ENGLISH HERITAGE
NORTH WEST OFFICE

15 November 2012

**Notifications under Circular 01/2001, Circular 08/2009 &
T&CP (Development Management Procedure) Order 2010**

**LAND AT HIGHER STANDEN FARM, CLITHEROE, LANCASHIRE
Application No 3/2012/0942**

Scale: 1:2500@A2 Job: 5381
 Reviewed by: GP Drawing: SP(90)09E

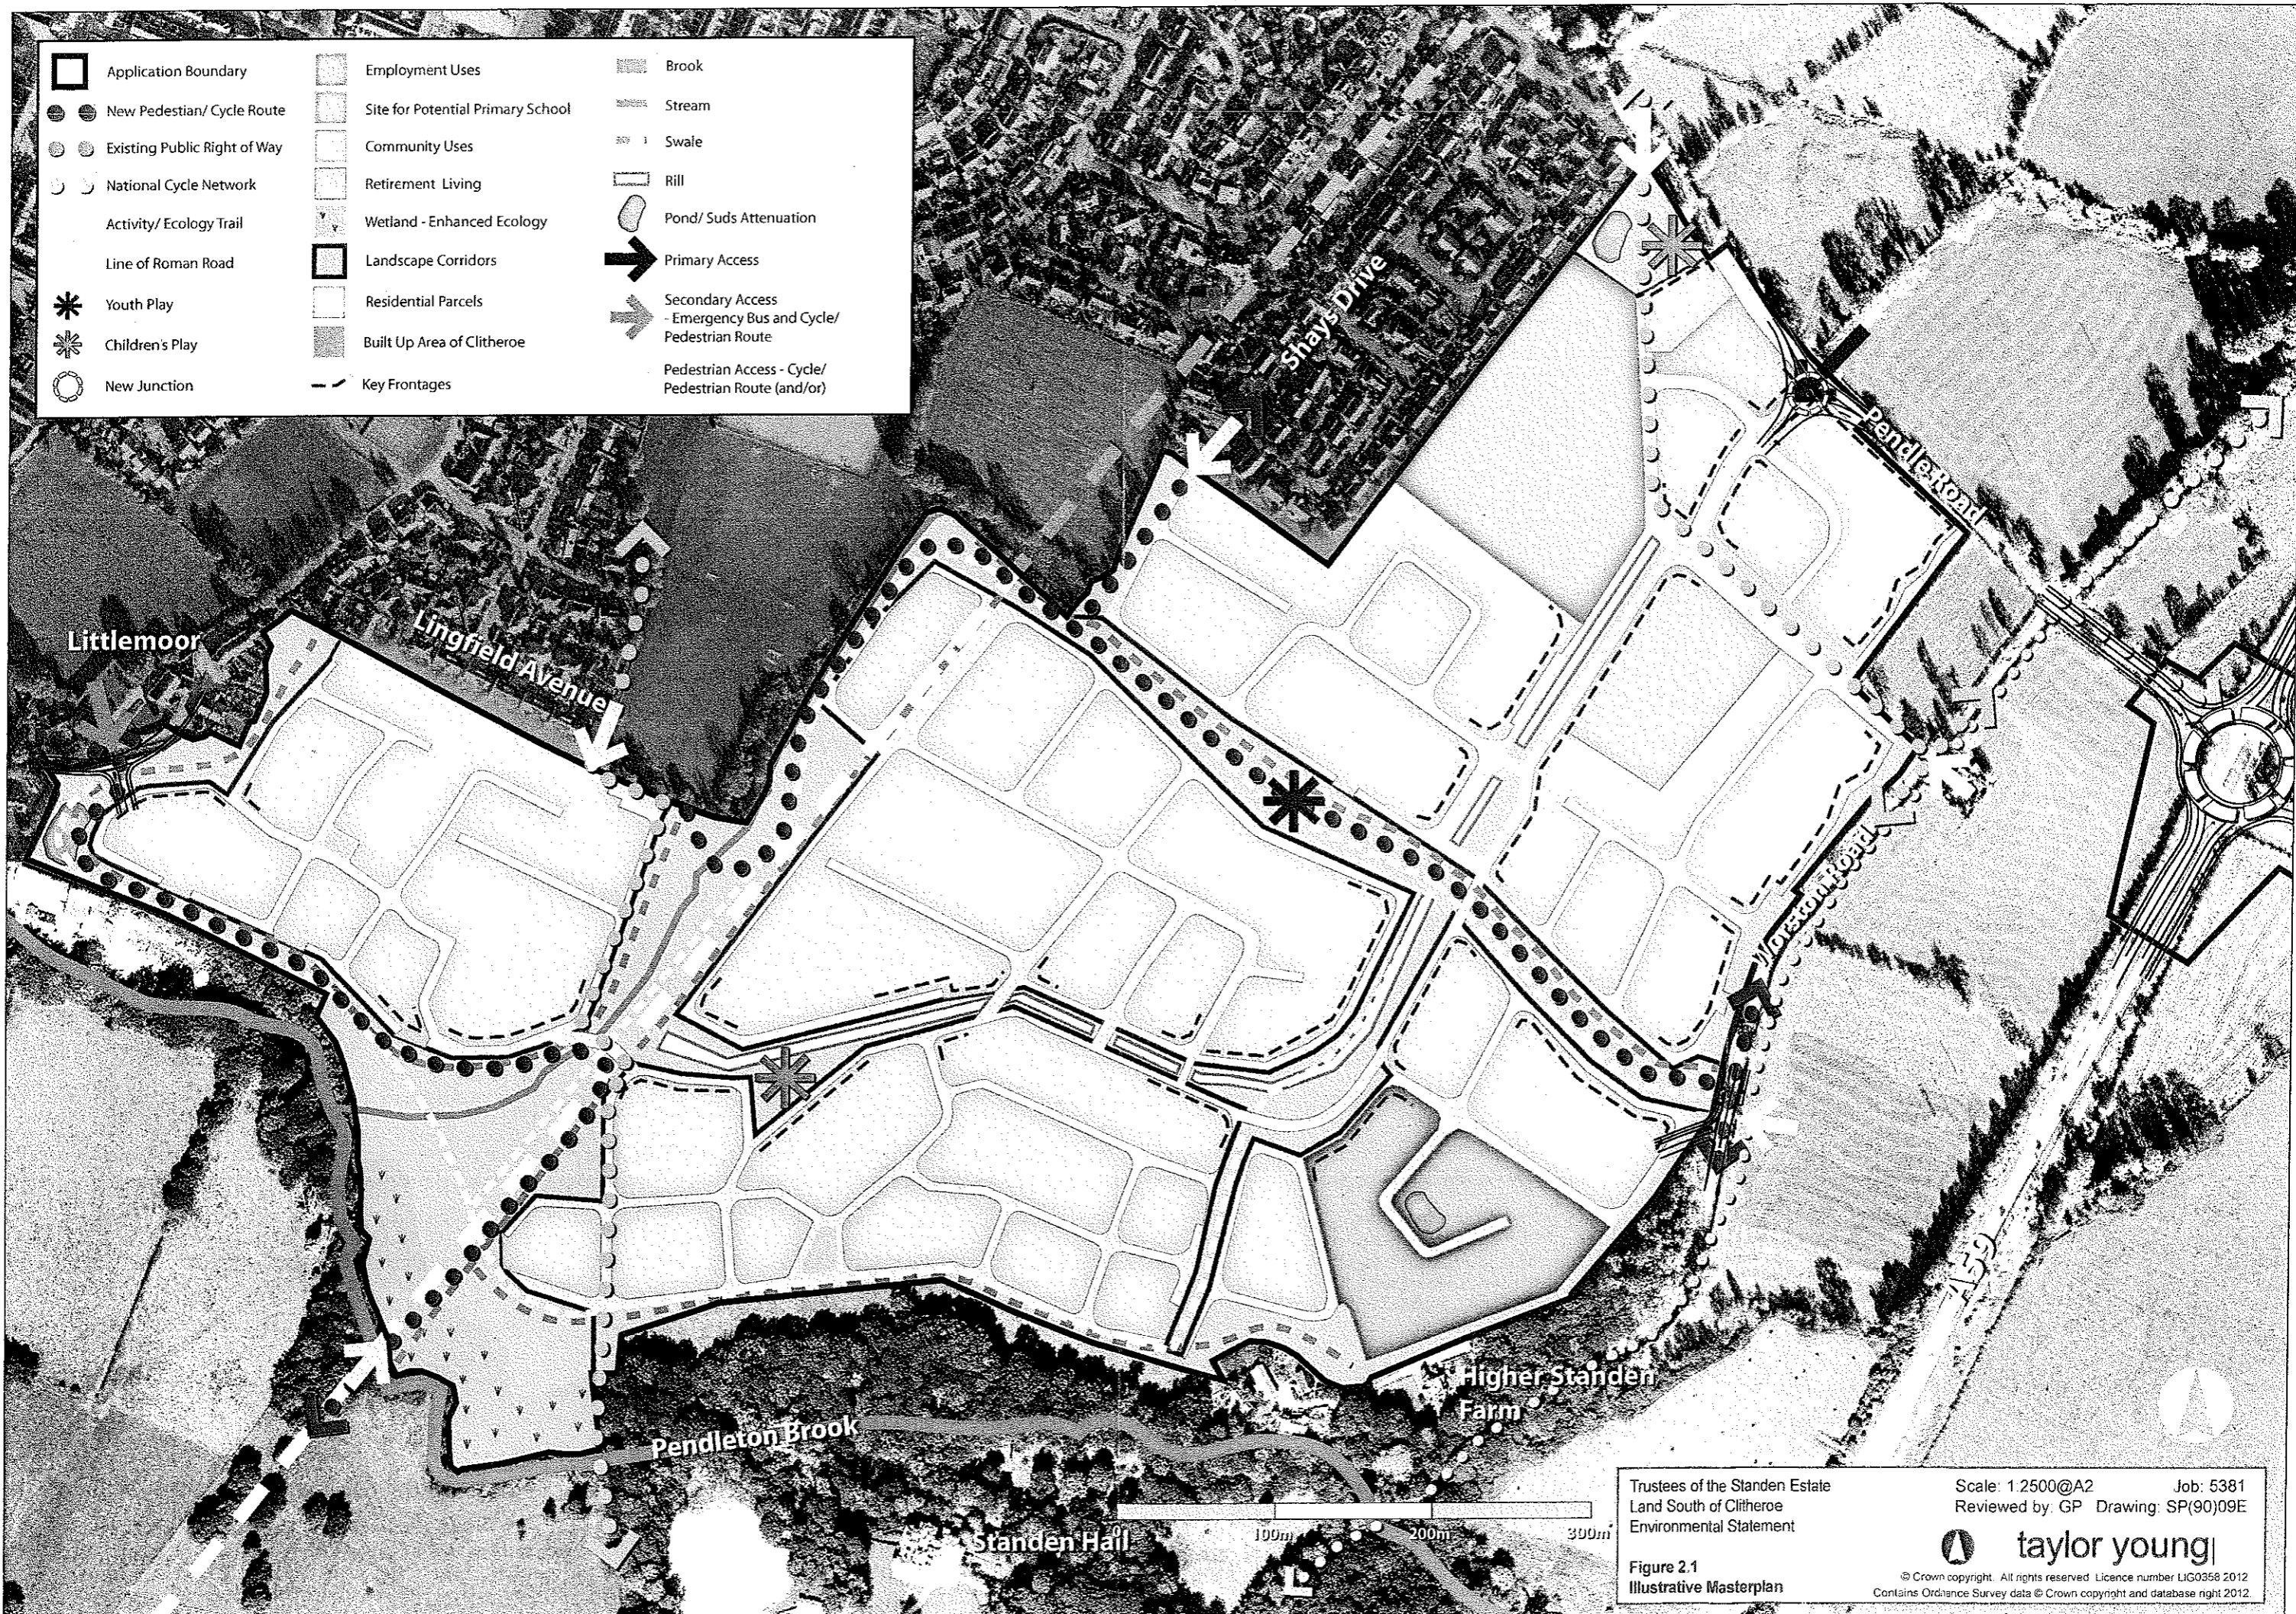
English Heritage does not object to the proposal as shown on the illustrative masterplan in principle. However, in our view, the information submitted to support the application does not contain an adequate assessment of the significance of the designated and non-designated heritage assets affected and the contribution that setting makes to their significance which means that nature and extent of the impact and effects cannot be properly assessed in line with government policy and guidance. Or to allow/enable adequate mitigation measures (through the imposition of planning conditions) to be incorporated into the development proposal at the earliest stage.

There is direct evidence for a Roman road crossing the site, the archaeological remains of which survive, and with regards to archaeological impacts we understand from the illustrative masterplan that the line of the Roman road is to be left marked as

part of an activity / ecology trail. We would also advise that consideration should be given to the preservation *in situ* of any associated remains and in advance of granting consent for any development there should be trial trenching investigation. The details of this should be agreed with the County Council Archaeological Service.

We also advise that the opportunity to explain the significance of the Roman road and to allow it to be appreciated and understood as an important feature of the site, for example through putting up interpretation panels should be explored. The NPPF includes within its definition of sustainable development the protection and enhancement of the historic environment and the need to seek positive improvements.
